December 20, 2022

RE: Notice of Incomplete Application for File No. SUB22-008

With respect to your notice of incomplete application for file number SUB22-008 dated November 30<sup>th</sup>, 2022 we are submitting the below specific responses:

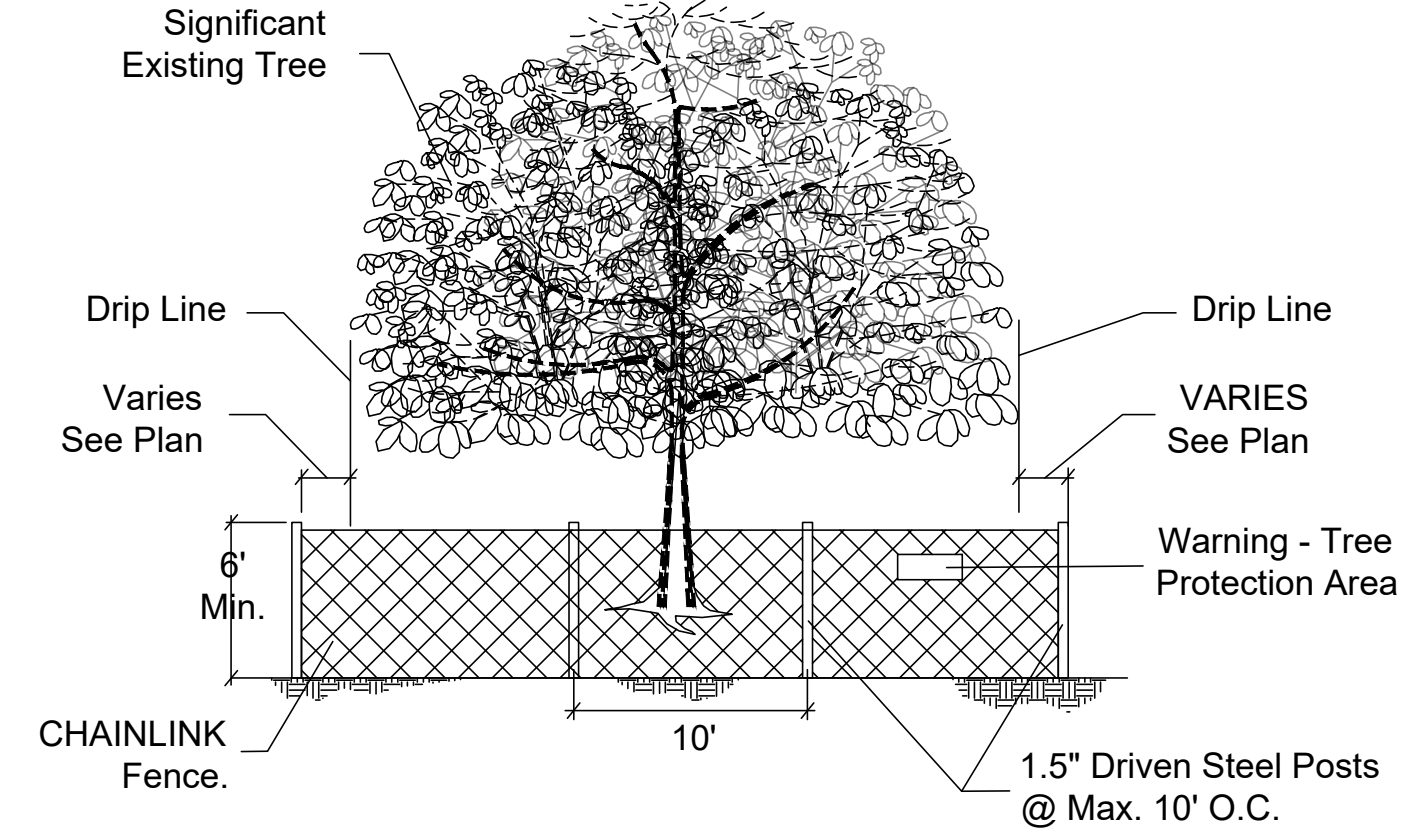
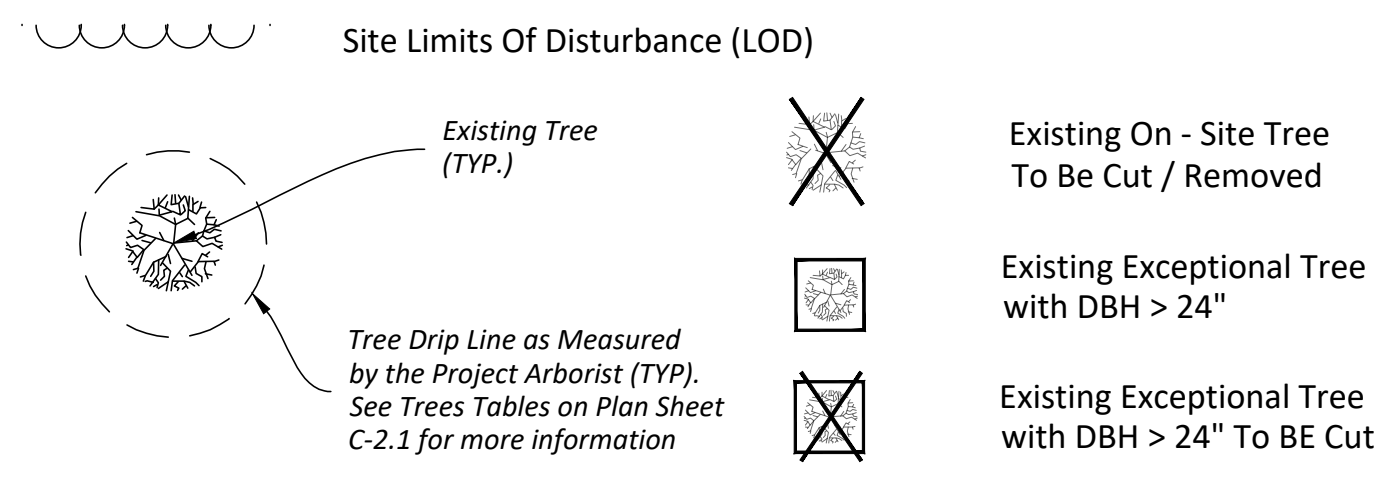
*MICC 19.19.060(A)(2)(a) requires retention of 30% of trees on the site with a diameter of 10 inches or greater. Additionally, development must be designed to minimize tree removal. The project cannot be approved unless the tree retention requirements are met.*

Consistent with MICC 19.19.060(A)(2)(a) and utilizing Arborist Report dated April 20<sup>th</sup>, 2022 prepared by Thomas Hanson of ARBOR INFO LLC, we are attaching revised Tree Tables Plan C-2.1 and Trees Retention Plan C-3.0 for city review. These plans will show total of 69 trees surveyed by the project surveyor and referenced in the Arborist Report, out of the 69 existing trees there 26 trees that are considered unregulated trees with DBH < 10" and/or trees that are in poor conditions as referenced in the Arborist Report. This leaves total 43 viable existing trees which include regulated trees with DHB > 10" plus trees that are fair / good conditions.

The attached plan sheets will show total 32 trees proposed to be removed to make room for the construction of proposed 4 houses, proposed 4 individual driveways, proposed on-site access road, proposed water and sewer connections, and proposed on-site storm water retention / detention (R/D) system with associated storm conveyance system.

Out of 32 trees there are 8 trees that are unregulated with DBH < 10" and/or in poor conditions as referenced in the Arborist Report, leaving 24 viable trees to be removed, this means percentage of actual viable trees to be retained is  $43 - 24 = 19 \Rightarrow (19 / 43) \times 100 = 44.2\%$  exceeding the minimum 30% of required trees to be retained. Please refer to attached Civil Plans sheets C-2.1 and C-3.0, to attached Table – A (unregulated + poor conditions trees) and to Table – B (viable trees to be removed).

Additionally, consistent with the referenced Arborist Report, there are 14 existing trees with DBH of 24" and greater that are considered Exceptional Trees per MICC 19.10.070, out of which 5 trees will be retained a percentage of 30.8 %, please refer to attached Table – C and to attached Civil Plans for additional information and clarification.
